## WESTMEAD CATHOLIC COMMUNITY EDUCATION CAMPUS ATTACHMENT E - RESPONSE TO OPEN SPACE CLARIFICATIONS

**Note:** We have previously quoted the open space within the building (from Levels 1 – 5) as being ‘over’ 7,800sqm. When combined with the previously quoted ground level open space area of 6,070sqm, there was a total provision of 13,870sqm of open space, or 8.26sqm per student. To be conservative, this was rounded down to 8.2sqm per student.

OPEN SPACE - LEVEL 02 & LEVEL
03

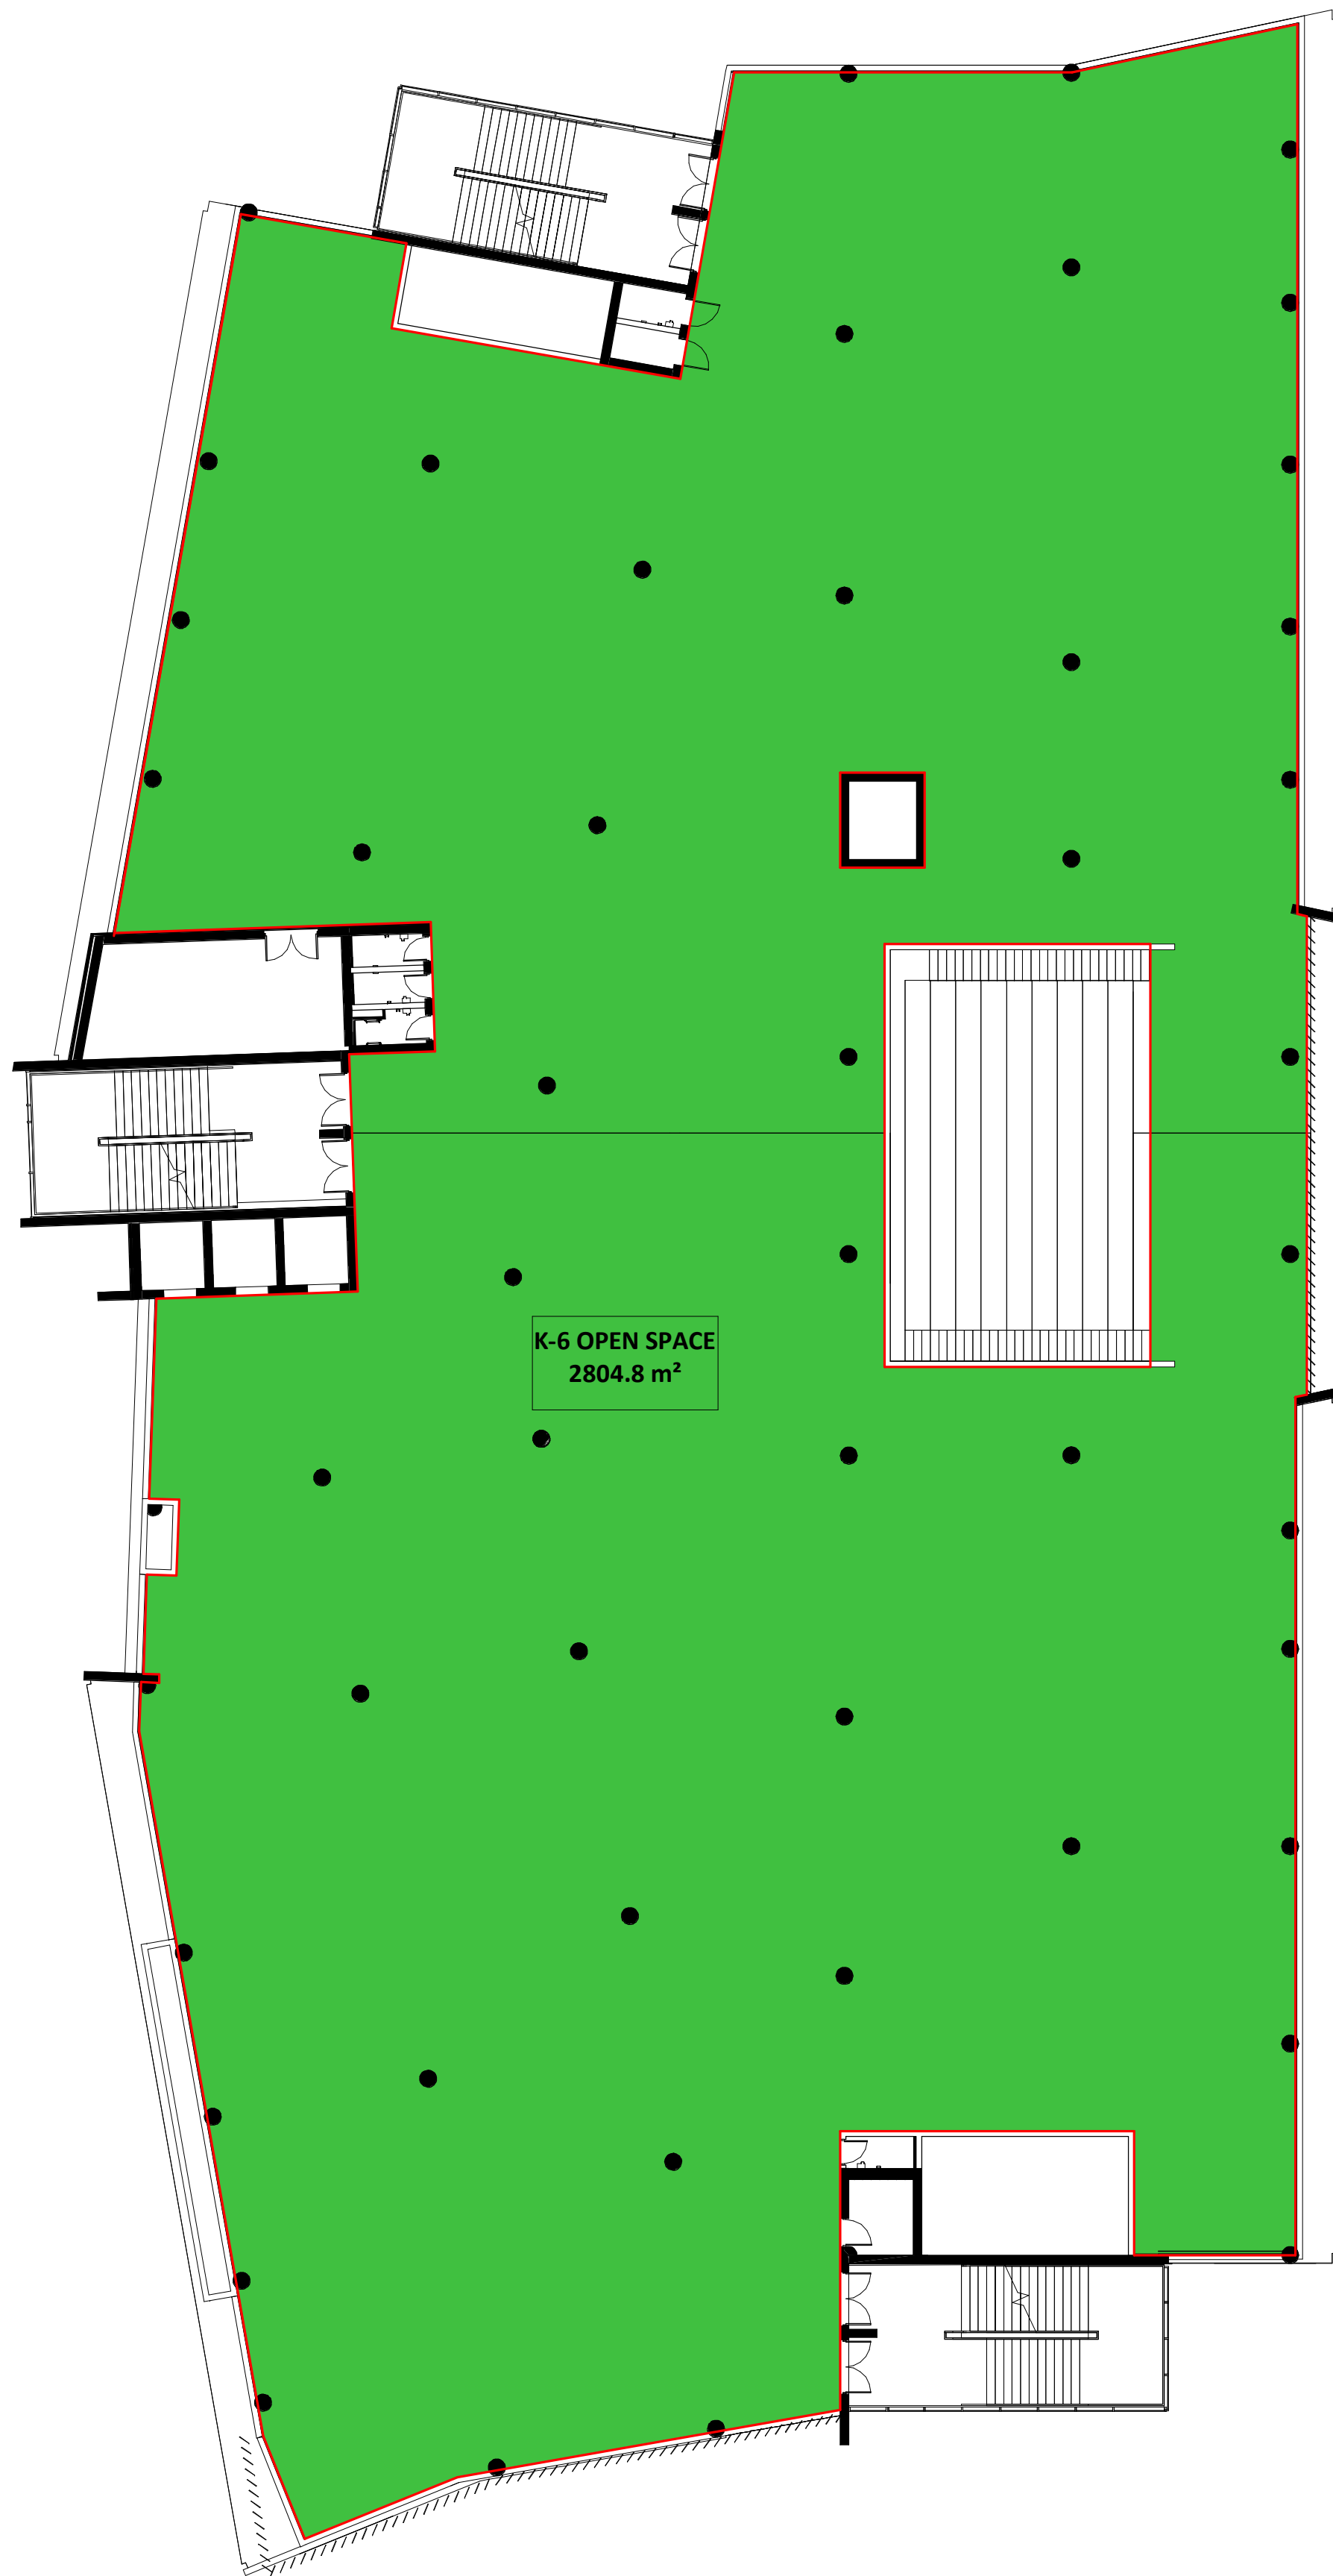
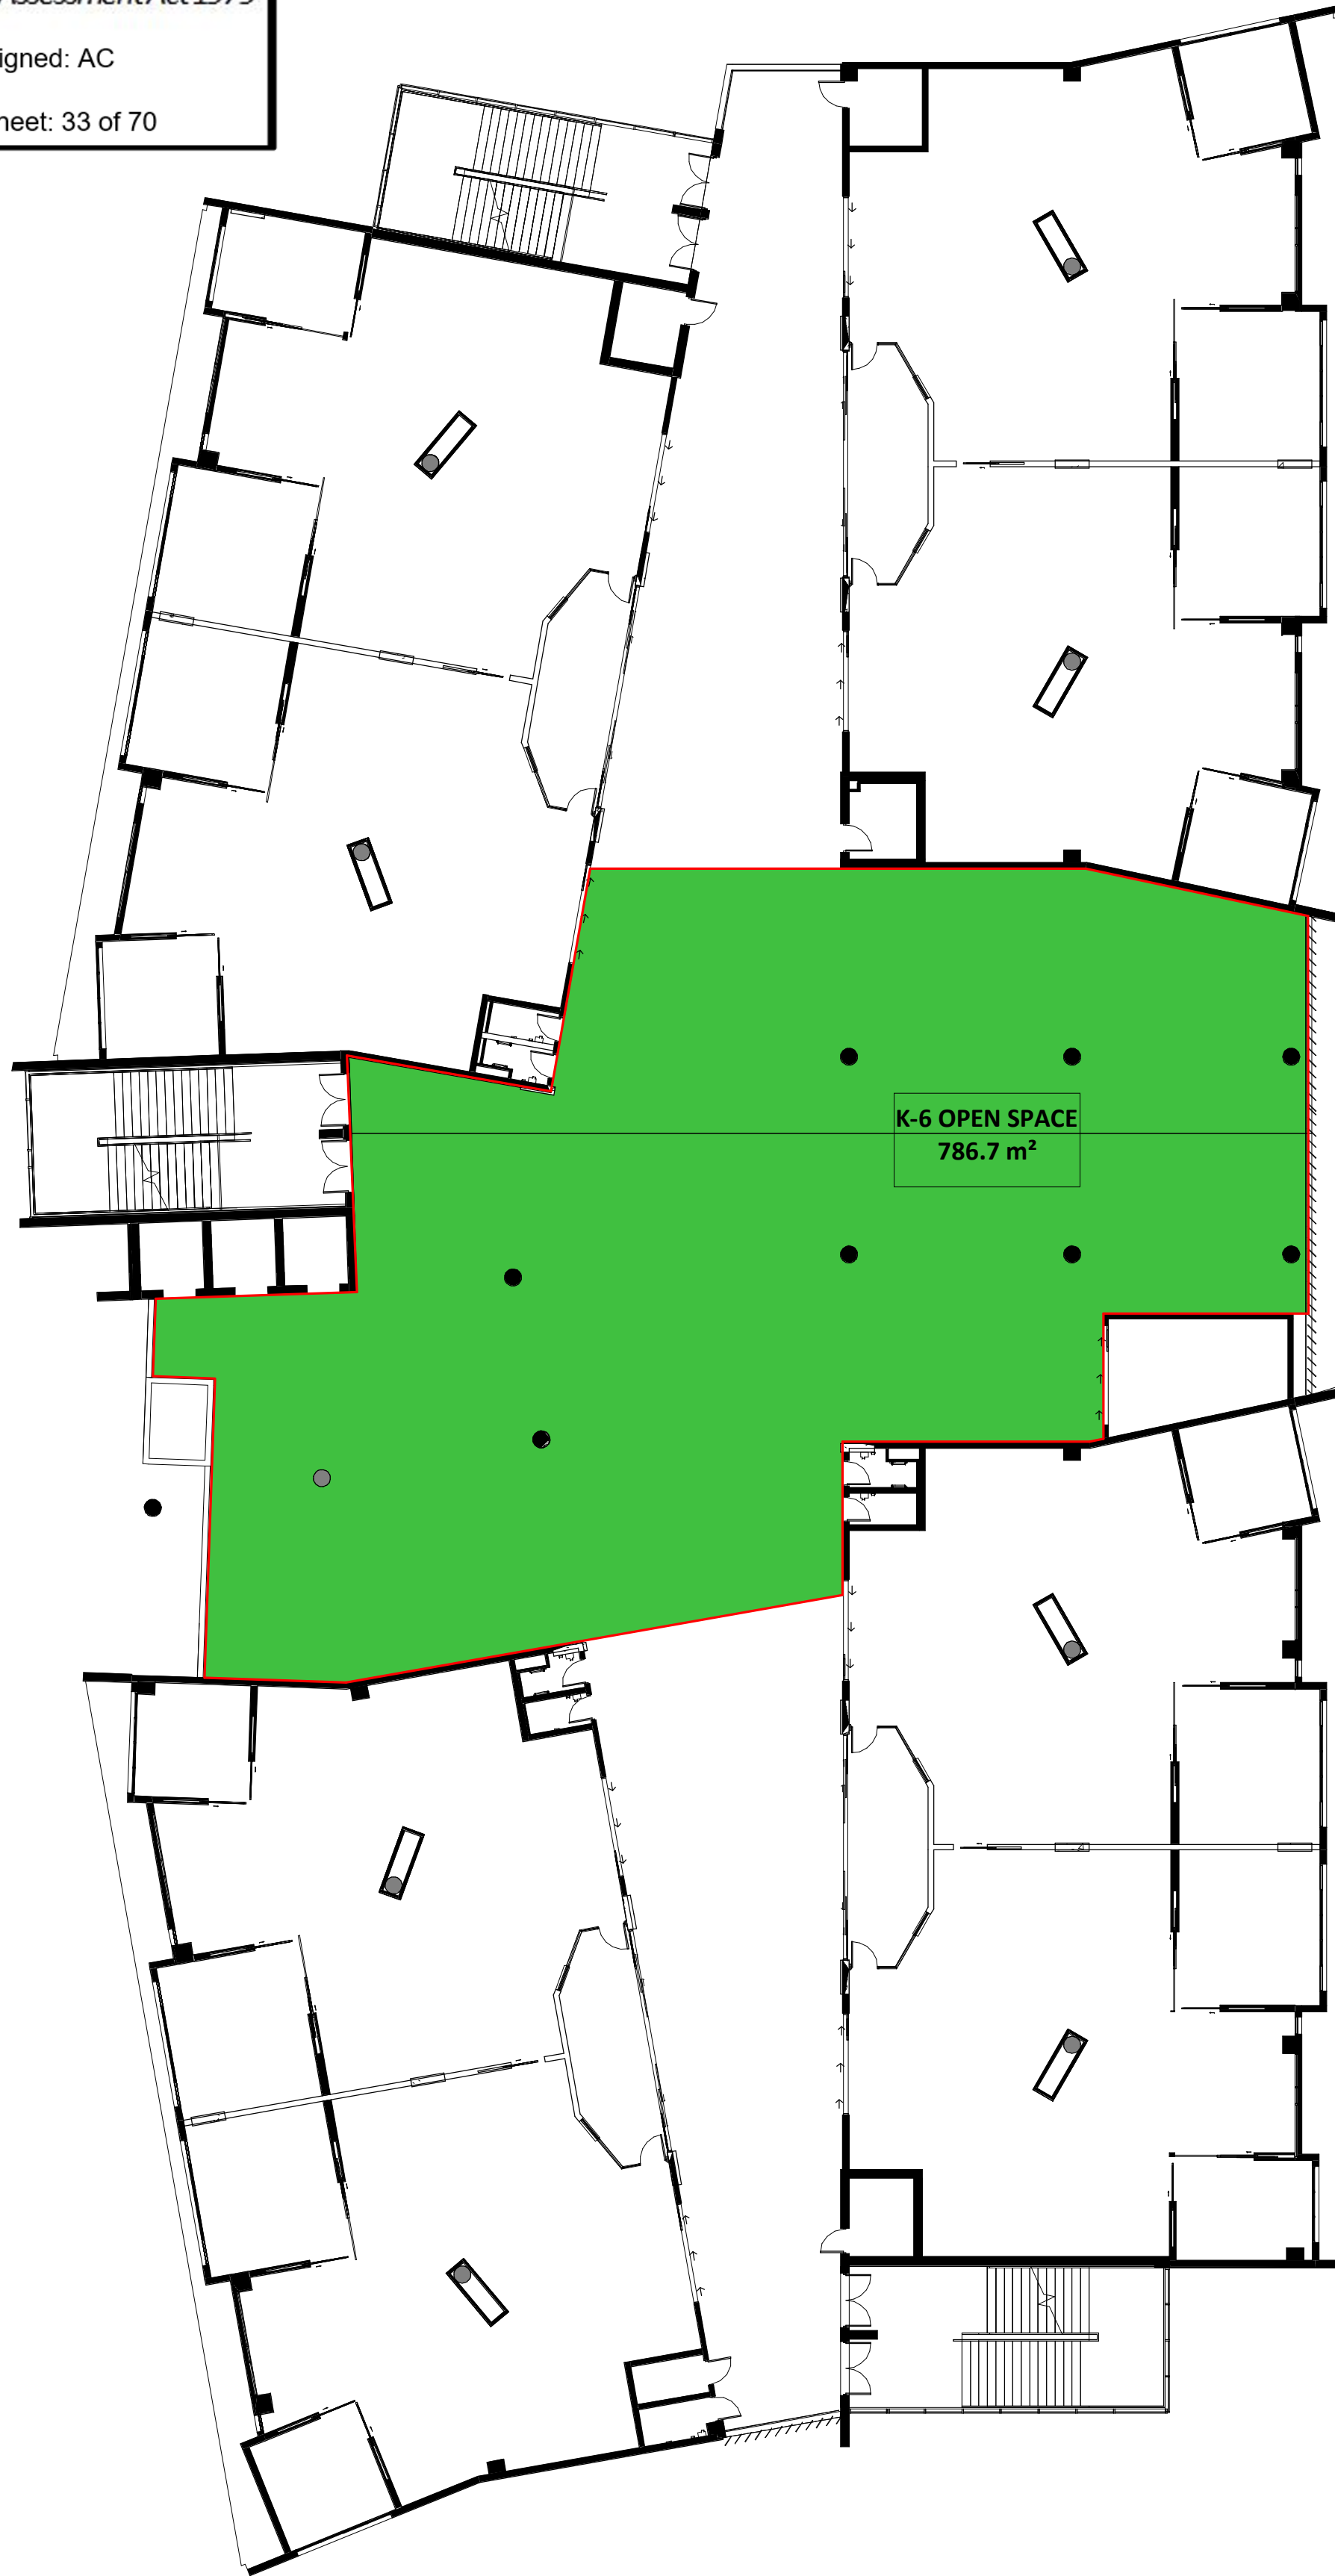
b	The Response to Submissions (RtS) advises that the outdoor play spaces would be divided between year groups (K-2 at ground and Level 1, Years 3-4 at Levels 4 and 5, and Years 5-6 at Levels 2 and 3). The application also advises that the school building has been designed to minimise vertical movement to one level up or down, where possible. However, the plans note that each outdoor play space would be accessible for all K-6 students. Please clarify the quantity of open space to be provided per student for each year	<p>It is noted that primary students of all year groups will have access to all play areas at the ground level and upper levels of the building, with access to ultimately be determined by operational factors such as supervision and suitability, which will be determined by the teachers when the school becomes operational.</p> <p>However, as described in DPIE's comment, dedicated open space areas have been identified for different year groups. These open space areas are provided adjacent classrooms with a vertical</p>

Item No	Clarification	Response
	<p>group (e.g. Years 5 and 6 students at Levels 2 and 3). Please also quantify the amount of unencumbered ground level open space access to be provided for each year group. This information should be provided in a table/schedule format.</p>	<p>connection one level up or one level down to significant play space so as to minimise circulation time and maximise recreation opportunities. Whilst all students will have access to ground level open space, as noted in DPIE's comments, the ground level is identified to be used primarily by Kindy – Year 2. For developmental reasons, it is not uncommon for younger students to have separate play areas to older students.</p> <p>Whilst there will be no dedicated area of ground level open space for other year groups, students will not be precluded from travelling between different levels of the building to access open space (from ground to upper levels) when it is appropriate to do so, such as during free play. This will be managed by CEDP via an operational guideline, which will ensure that all students have access to open space that is appropriate for their needs, both in terms of quantity and design.</p> <p>A schedule of open space provision by year group is <b>attached</b>. It shows that some year groups notionally have more open space than other cohorts, as follows:</p> <ul style="list-style-type: none"> <li>Kindy, Year 1 and Year 2 = 9.31sqm (Ground and Level 1)</li> <li>Years 3 and 4 = 7.43sqm (Levels 4 and 5)</li> <li>Years 5 and 6 = 7.42sqm (Levels 2 and 3)</li> </ul> <p>This breakdown shows that the variations between cohorts are minor, and the year groups with slightly less open space still receive a sufficient provision of purpose-designed play space. Further, when considered across the broader primary school area, students will each have access to 8.2sqm of dedicated primary school open space.</p> <p>Finally, we note that these figures exceed the current open space provision for Mother Teresa students (7sqm/student) and would significantly exceed the provision at Sacred Heart Primary School, once the play space is no longer available (2.3sqm/student). This demonstrates the urgent need to relocate students from the existing Sacred Heart Primary School site.</p>

Year Group	No. Students	Open Space	Open Space Per Student/m2
Ground	Kindy	240		
Level 1	Yr 1	240	6,704	9.31
	Yr 2	240		
Level 2	Yr 5	240		
	Yr 6	240	3,560	7.42
Level 3				
Level 4	Yr 3	240		
	Yr 4	240	3,564	7.43
Level 5				
<b>Total</b>		<b>1,680</b>	<b>13,828</b>	<b>8.23</b>
